Road Safety Audit Report

Incorporating
Stage 1 Completion of Preliminary Design.

Proposed Access off the A259 New Road, Rustlington

Job no	RSA-15-002	Issue no	4	Date	June 2015
Prepared by	JJF	Verified by	AJB	Approved by	JJF
Filename and Path	Fenley/Road Safety Audits/RSA-15-002-04

Title
HIGHWAY ACCESS PLAN

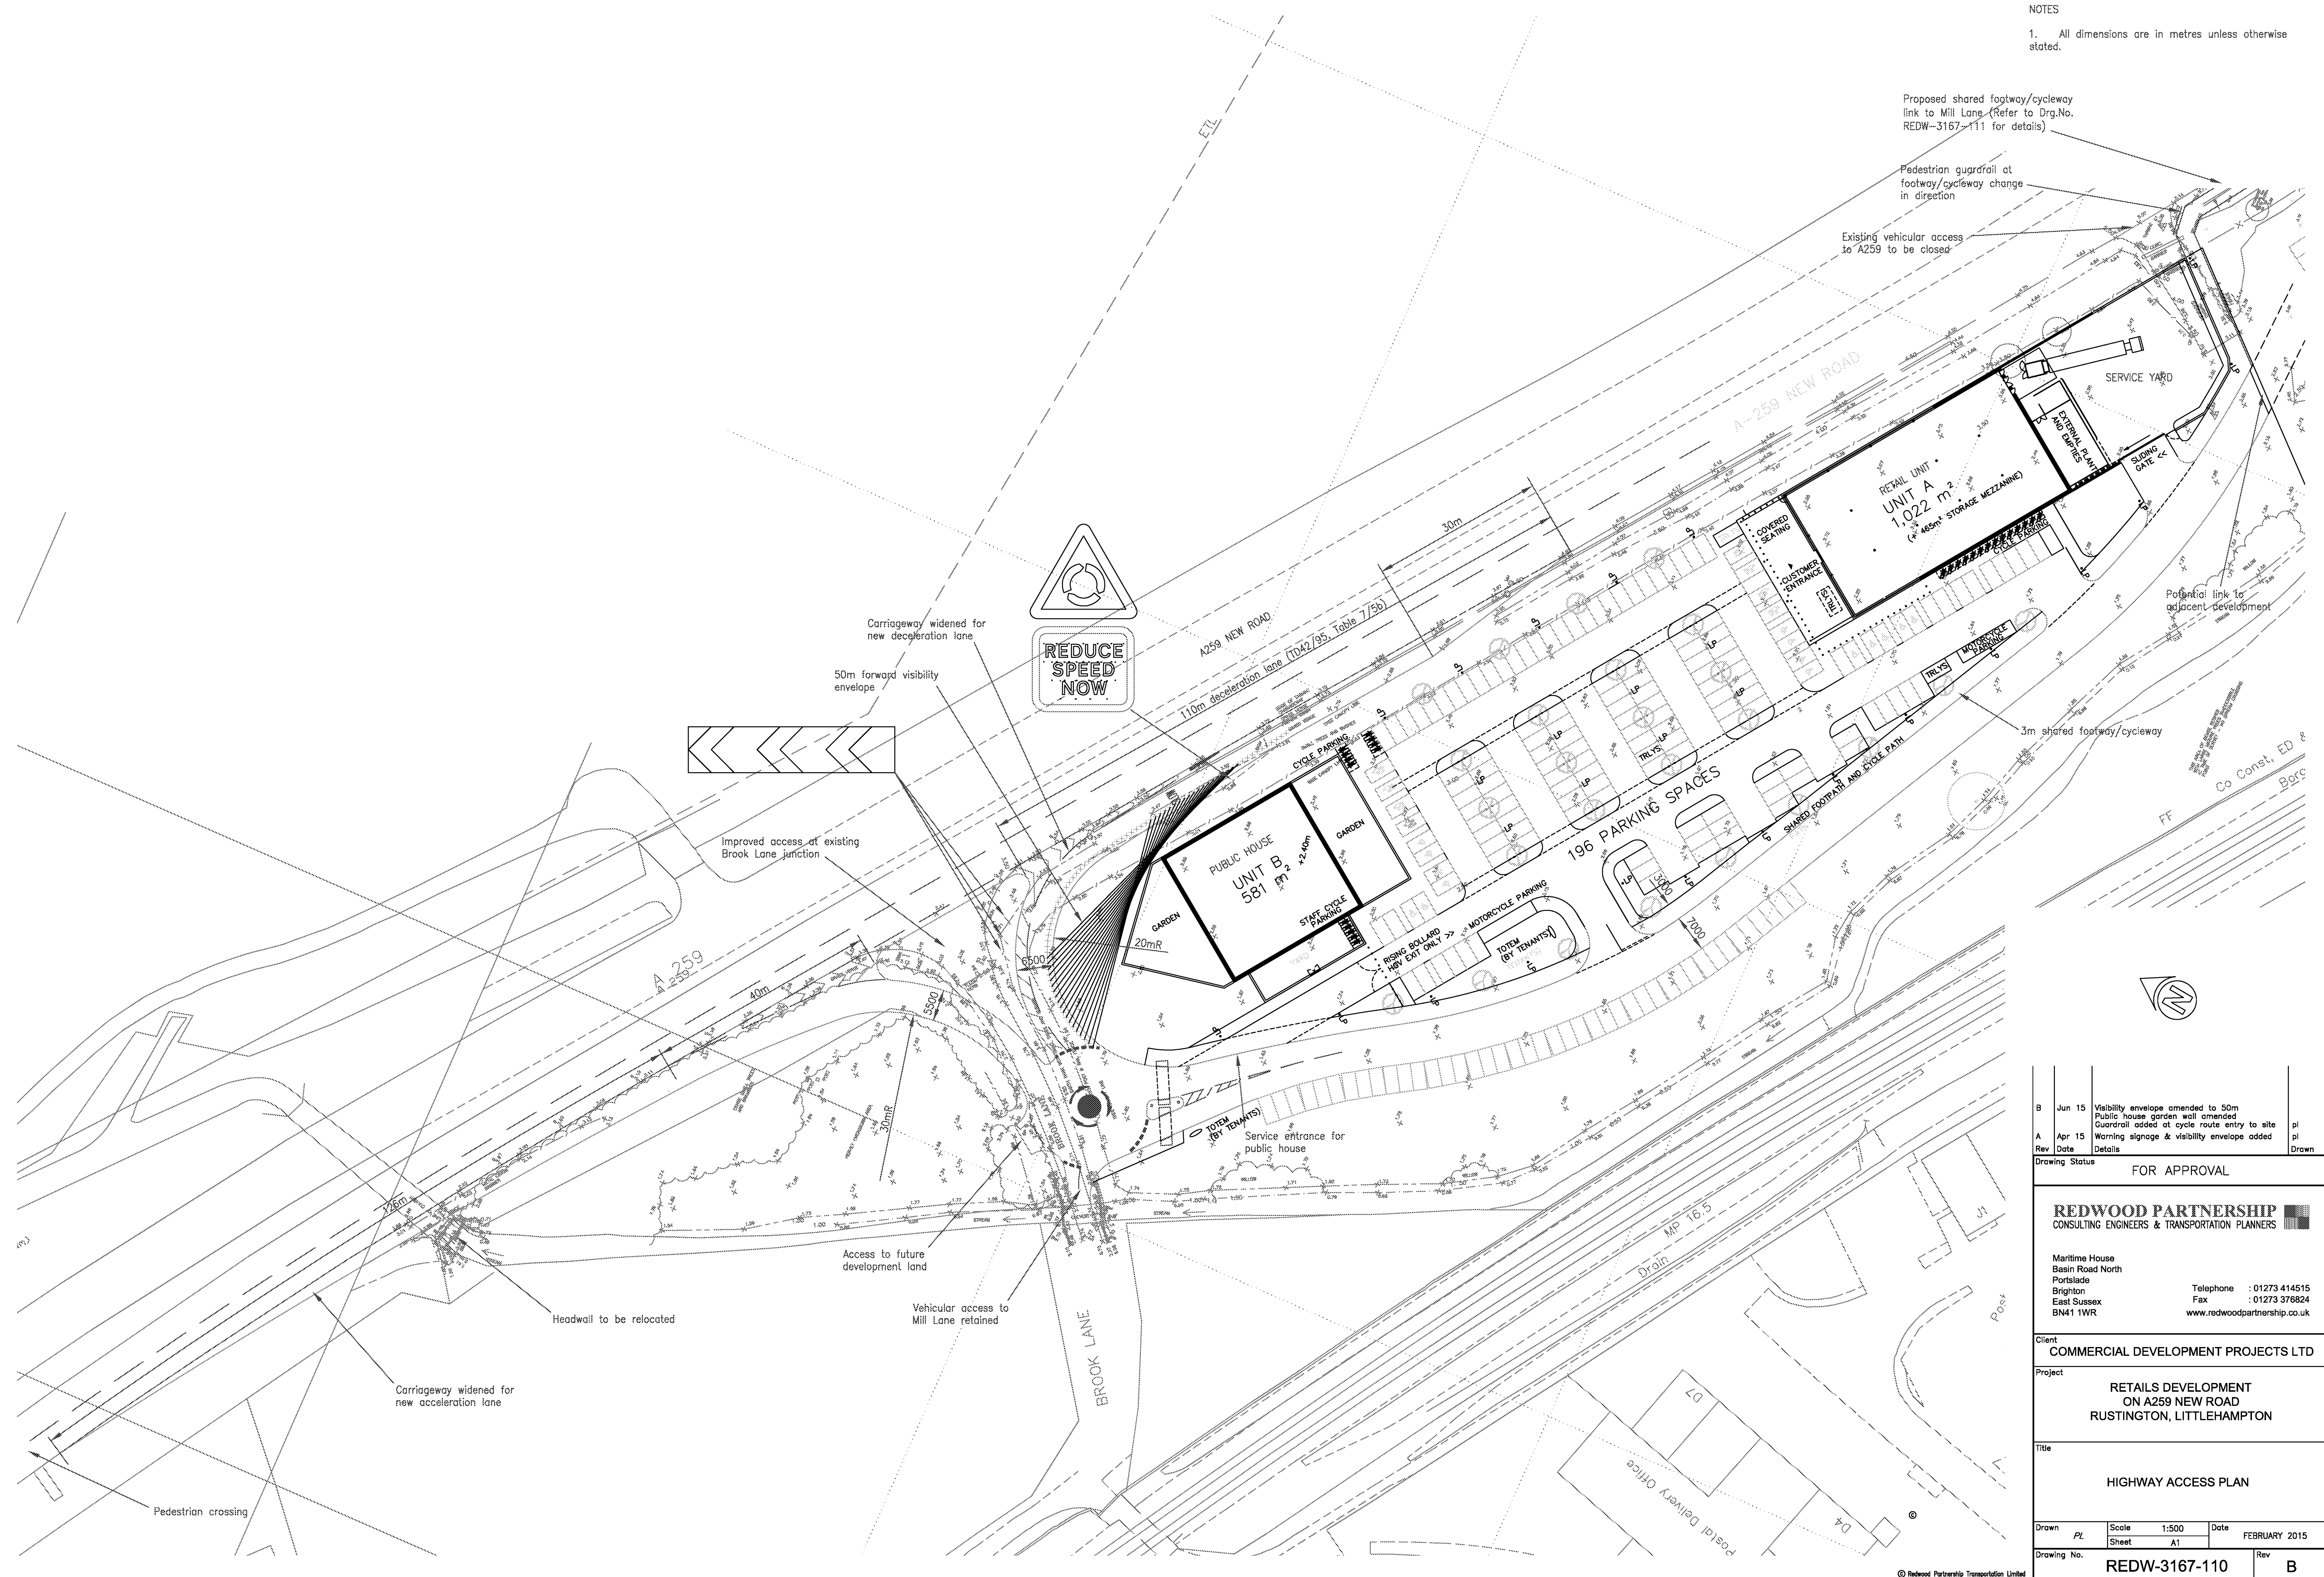
A.2	LOCAL ALIGNMENT	
A.2.1	PROBLEM Tight entry corner radius Accident Type <i>Loss of Control</i> Location Entry radius from deceleration lane <i>The proposed deceleration lane is provided for vehicles to decelerate from the derestricted A259. Vehicles could therefore be travelling in excess of the speed required to safely manoeuvre around the 20 metre corner radius. This could result in vehicles losing control and striking the island.</i> The appropriate chevron and warning signs should be installed in clear view of vehicles utilising the deceleration lane to ensure that drivers are aware of the corner. 	Chevron sharp deviation of route signs (Diag. 515) have been included on the central approach island as shown on Drg.No. REDW-3167-110-Rev A

Audit Item No.	Audit Team Observation	Audit Team Recommendation	Designer / Scheme Response
A.2.2	PROBLEM Restricted visibility around the exit corner radius Accident Type <i>Shunt</i> Location Inside of exit radius to the acceleration lane <i>Forward visibility vehicles accelerating from the roundabout to the acceleration lane to vehicles utilising the acceleration lane, is restricted by vegetation. Therefore drivers will not have a clear view of preceding vehicles. This could result in shunt type accidents should a driver hesitate and stop along the acceleration lane.</i>	Vegetation should be cleared to the appropriate level to allow for the clear forward visibility.	Vegetation will be cleared to a distance of 3m from the kerb line of the site at the radius of the site egress. The verge area adjacent to the carriageway will be offered for adoption as Public Highway

Audit Item No.	Audit Team Observation	Audit Team Recommendation	Designer / Scheme Response
A.3	JUNCTIONS		
A.3.1	PROBLEM Forward visibility to the roundabout is restricted Accident Type <i>Shunt type accidents</i> Location Roundabout Forward visibility to the give-way road marking at the roundabout from the deceleration lane is restricted to approximately 50 metres based on the building line of the adjacent pub/restaurant. This could be further restricted should a fence be erected around the associated grounds and could result in shunt type accidents where vehicles are stopped at the give-way.	Warning signs should be installed to ensure that approaching vehicles are aware of the presence of the roundabout and the pub/restaurant should be restricted from erecting a fence where it blocks forward visibility. 	Forward visibility to the site roundabout is restricted due to a boundary wall proposed around the public house garden area. The achievable forward visibility envelope is shown on Drg.No. REDW-REDW-3167-110-Rev A. An advanced warning sign of roundabout ahead (Diag. 510) and REDUCE SPEED NOW supplementary sign (Diag. 511) and SLOW road marking is proposed in advance of the roundabout which will mitigate the reduced forward visibility to the roundabout give way.

PROPOSED OFF-SITE FOOTPATH/CYCLEPATH LINK

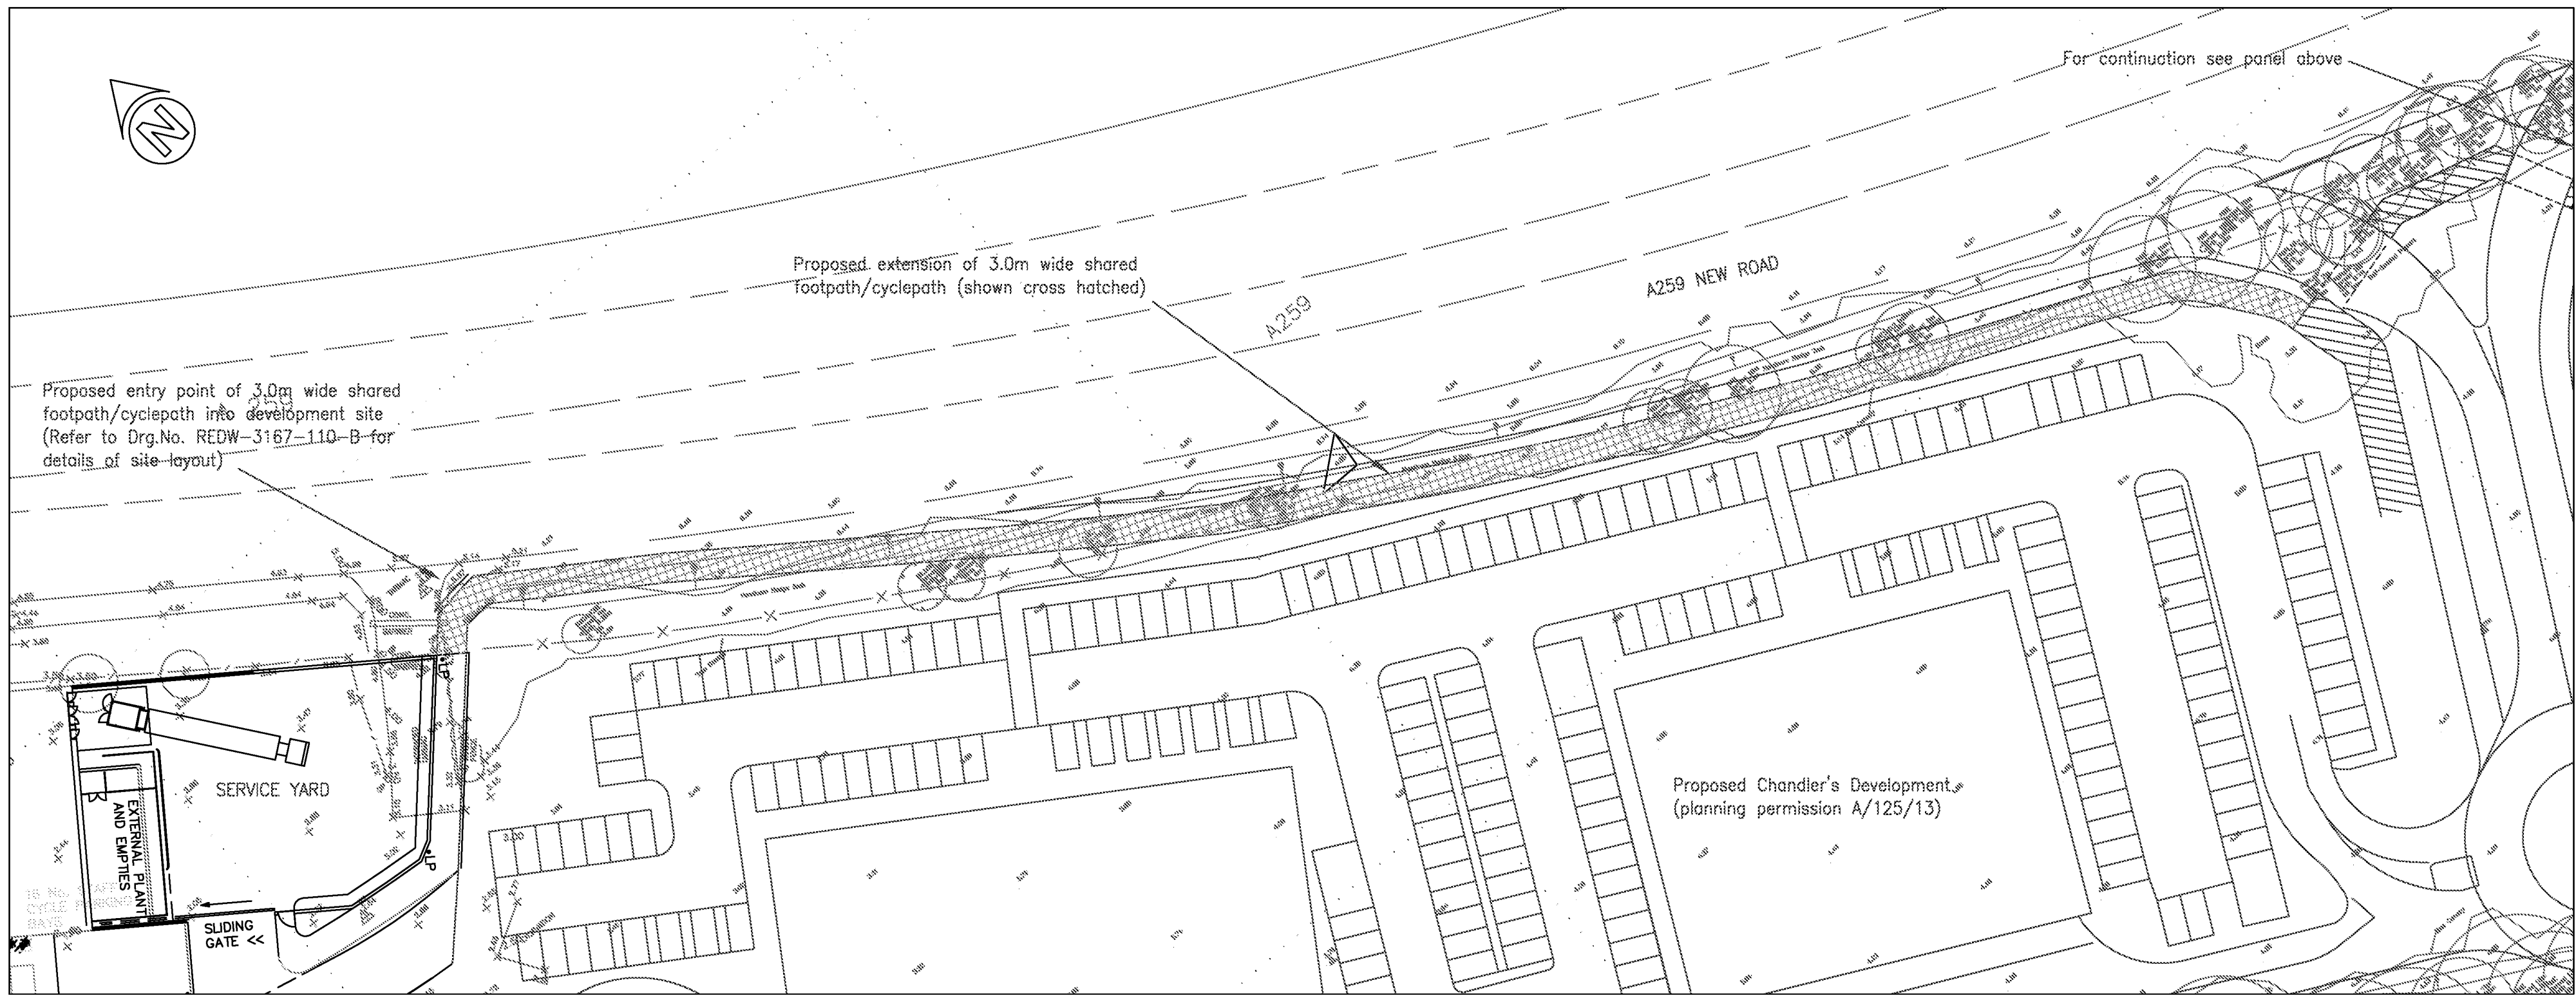
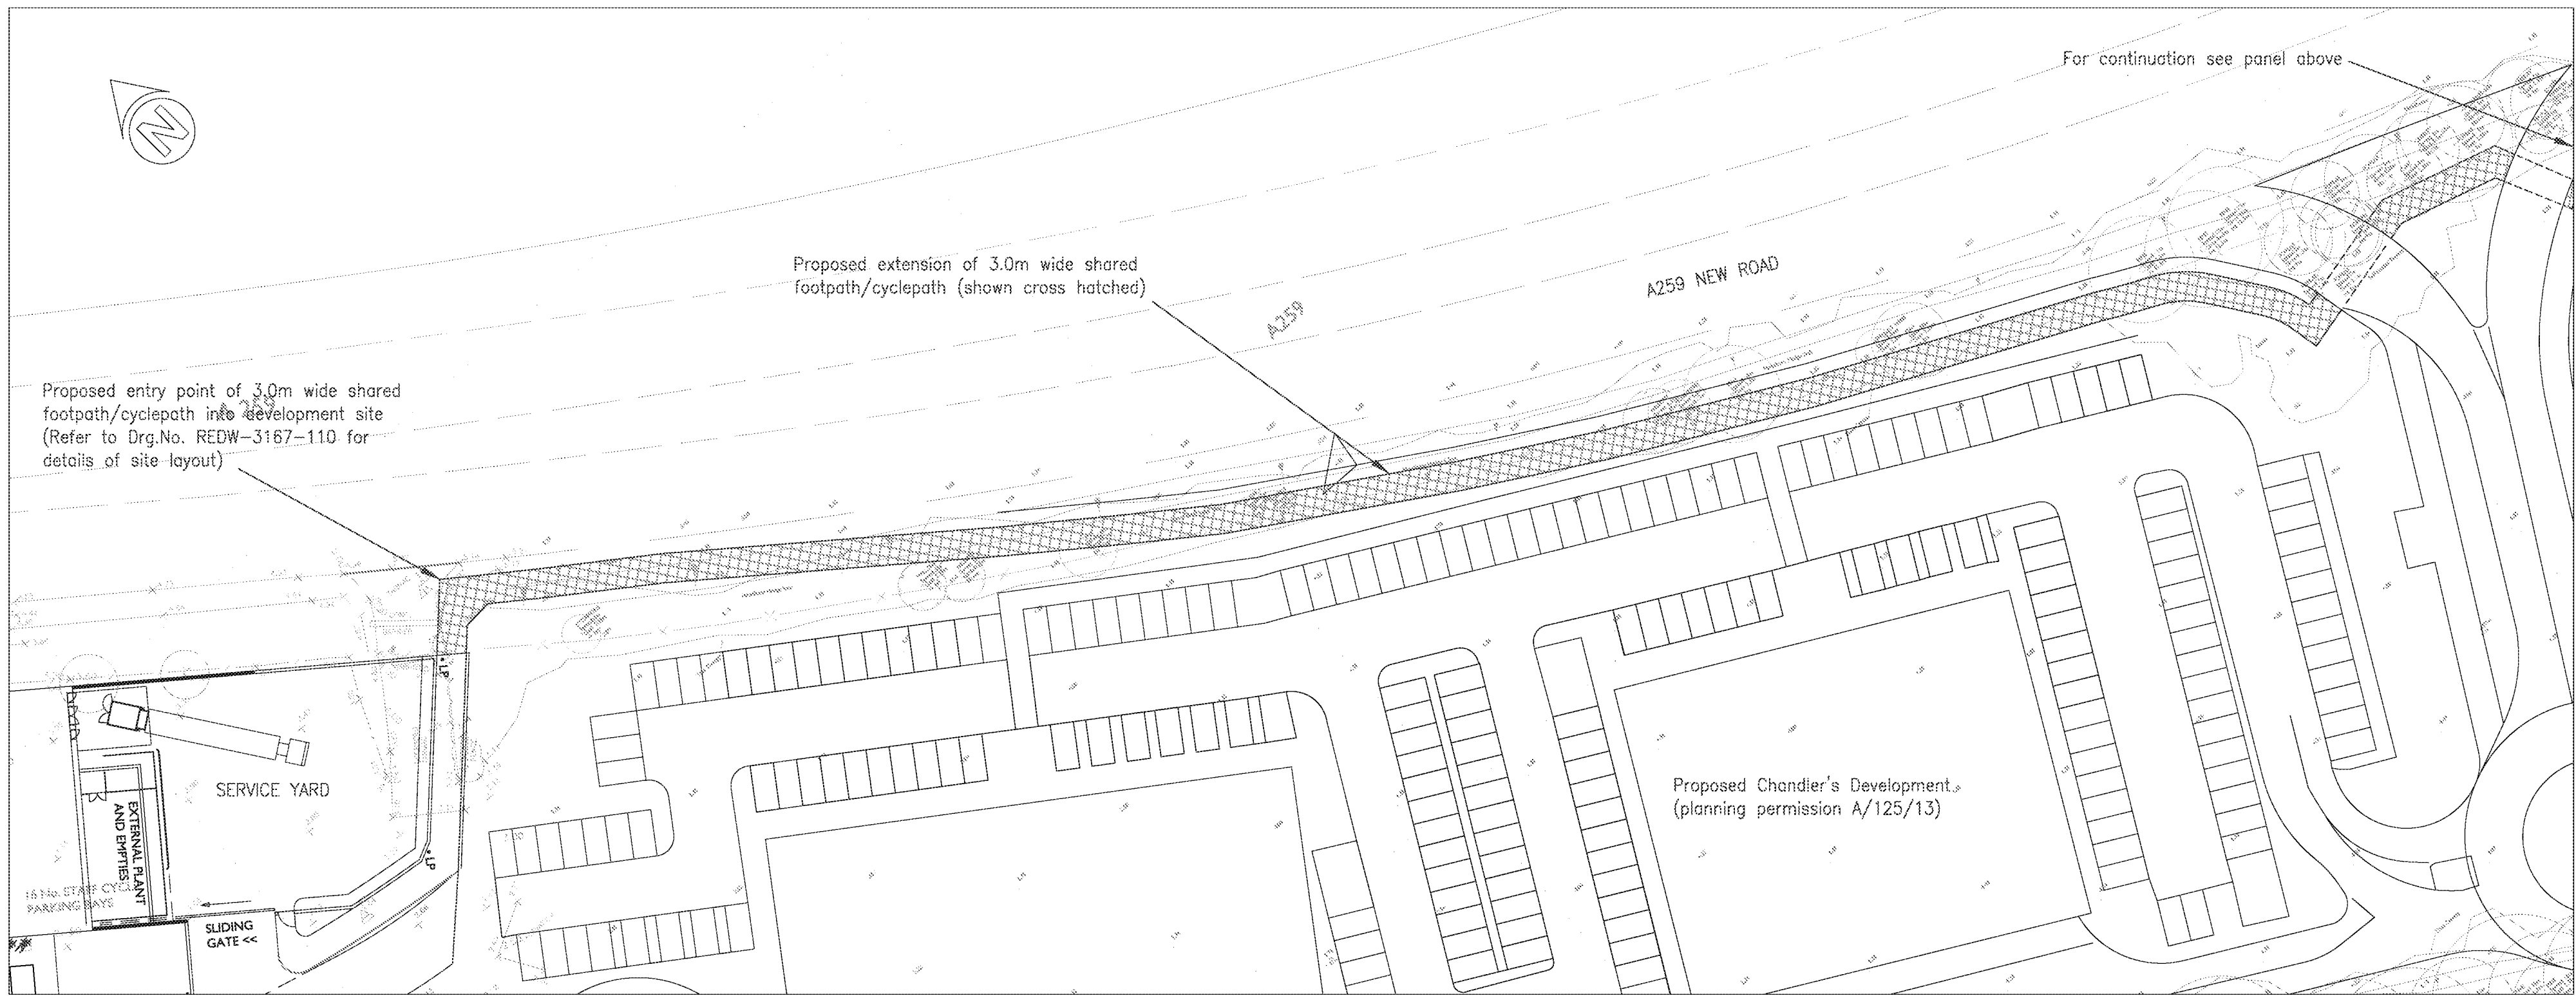
Audit Item No.	Audit Team Observation	Audit Team Recommendation	Designer / Scheme Response
A.4.2	PROBLEM Footway / Cycleway link guides into A259 carriageway Accident Type <i>Vehicle/Pedestrian, Cyclist Collisions</i> Location East of service yard The footpath/cyclepath link that is proposed, heads in a northerly direction adjacent to a service yard and bends 90° to a facility that is to run alongside the A259 carriageway. The 90° bend could result in cyclists losing control and pedestrians travelling into the path of vehicles on the A259. 	A section of guard railing should be introduced to ensure that non-motorised users follow the line of the footway/cycleway and do not enter the A259 carriageway.	A section of guardrail will be included at the detailed design stage. The guardrail will prevent non-motorised users from entering the A259 carriageway.
A.5	ROAD SIGNS, CARRIAGEWAY MARKINGS, LIGHTING AND DRAINAGE
